From: [CDS User](#)
To: [Jeff Watson](#); [Dusty Pilkington](#); [Chelsea Benner](#); [Dan Carlson](#)
Subject: FW: LP-17-00004MDJ longPlat and Currier Heights Planned Unit Development PD-16-00001
Date: Tuesday, May 23, 2017 3:58:41 PM
Importance: High

Currier Heights Planned Unit Development project file number PD-16-00001 and MDJ Contractors Long Plat file number LP-17-00004 MDJ Plat

SHEET NUMBER
A1.0

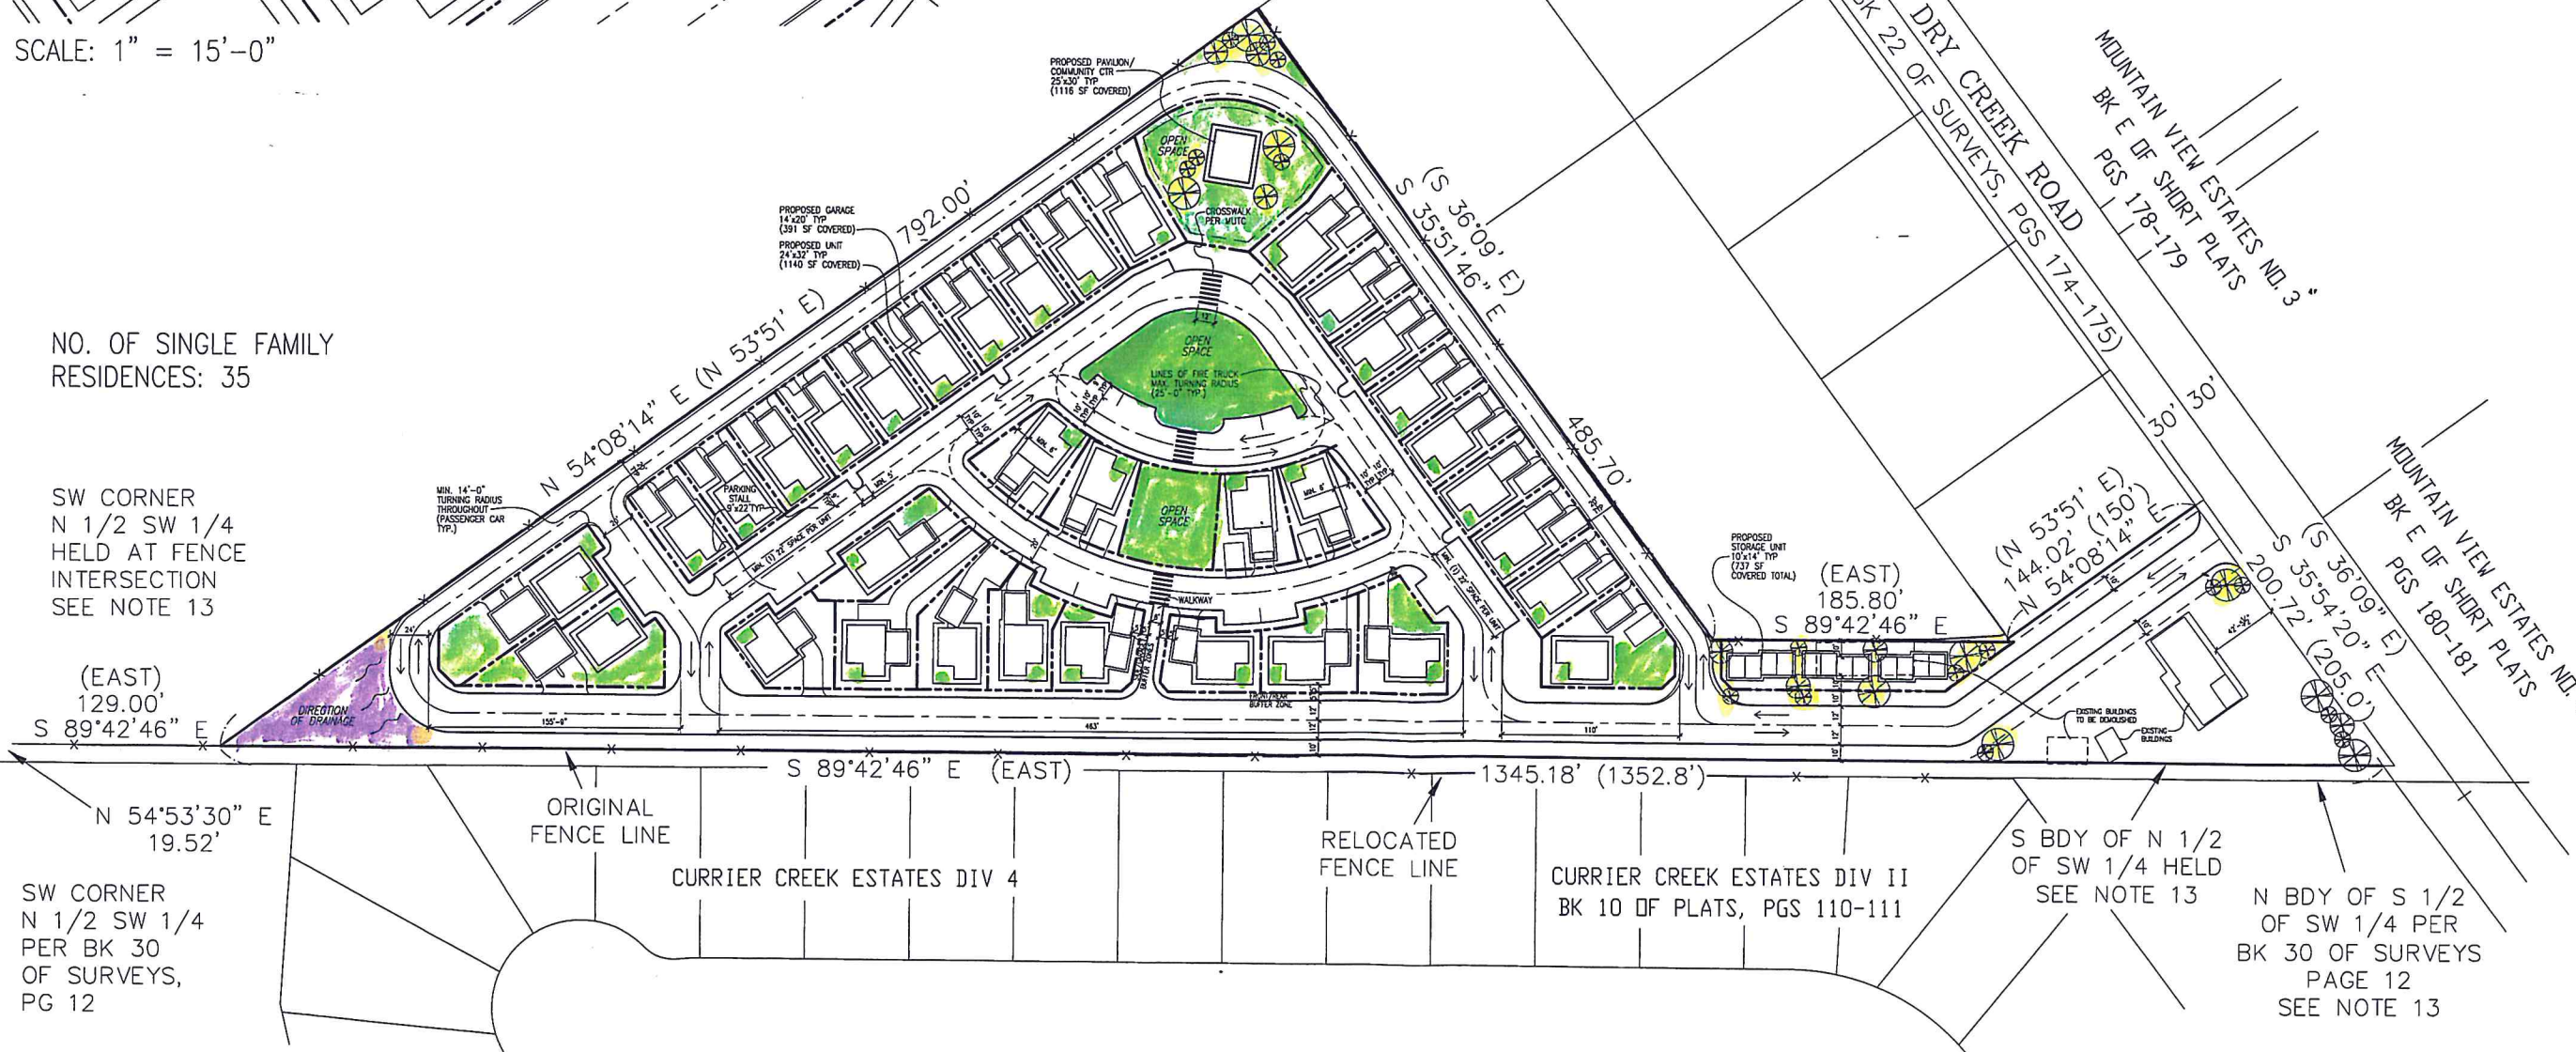
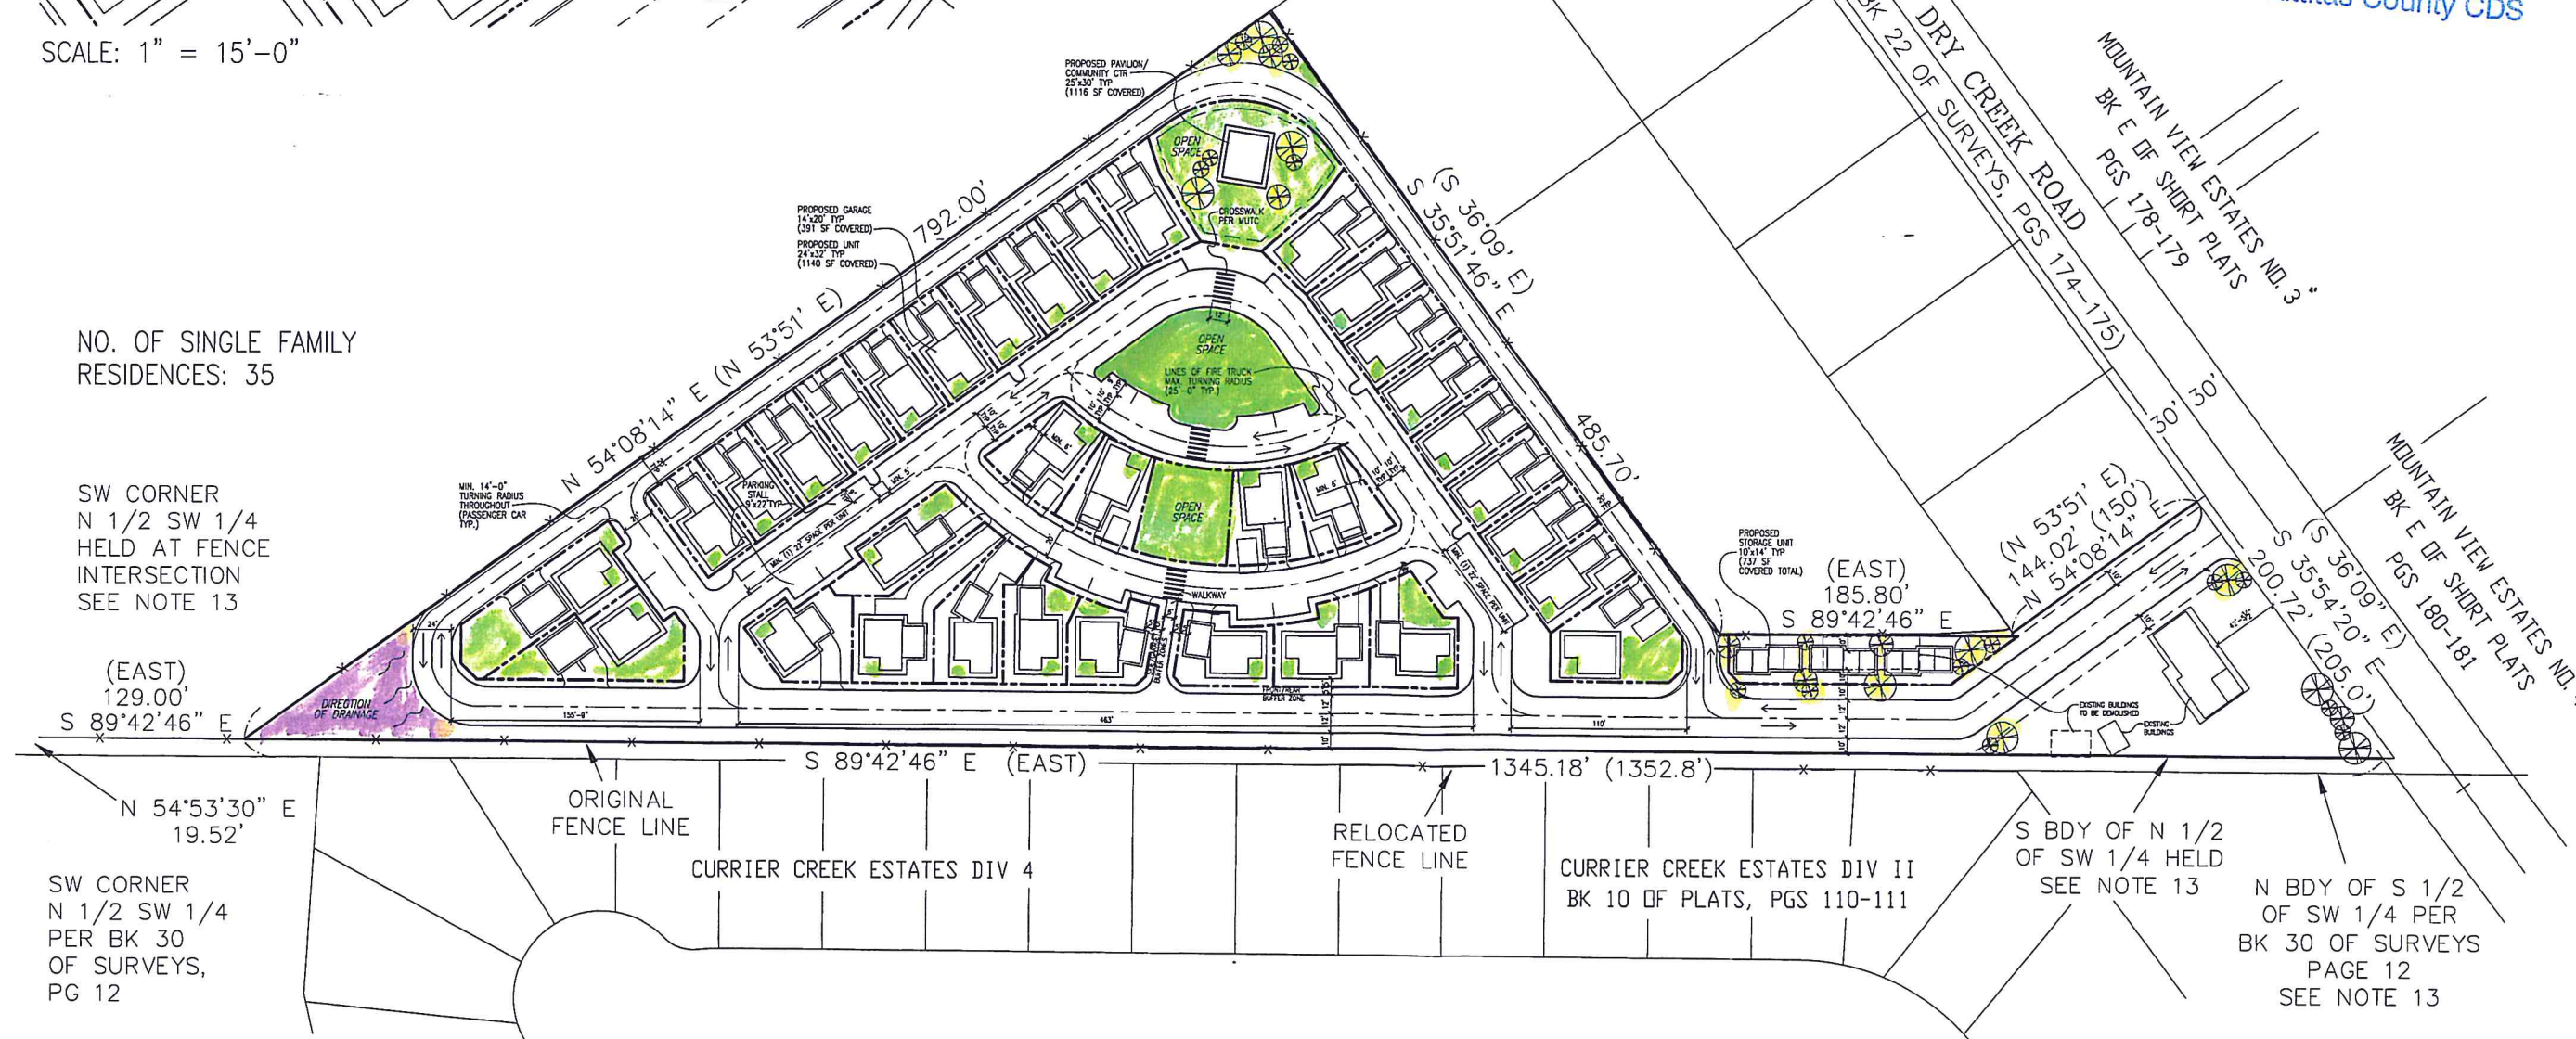
1. Our property is at the entrance/exit point for all traffic in and out of the development. Is a traffic impact study going to be undertaken to quantify the level of disturbance, annoyance and hazard caused by the number of trips per day stemming from an average of a minimum of 2.3 vehicles for each of the 35 houses?

3. If this development is approved, MDJ Contractors, LLC must be required to construct a solid wood fence along the length of our adjoining property lines. At this time, the house on our property is a rental house. If we have tenants with small children the tenant and us would be concerned about the proximity of the roadway without a barrier. We request to reserve the right to approve the location, length, dimensions and quality of the material for the fence. The maintenance and repair/replacement of the
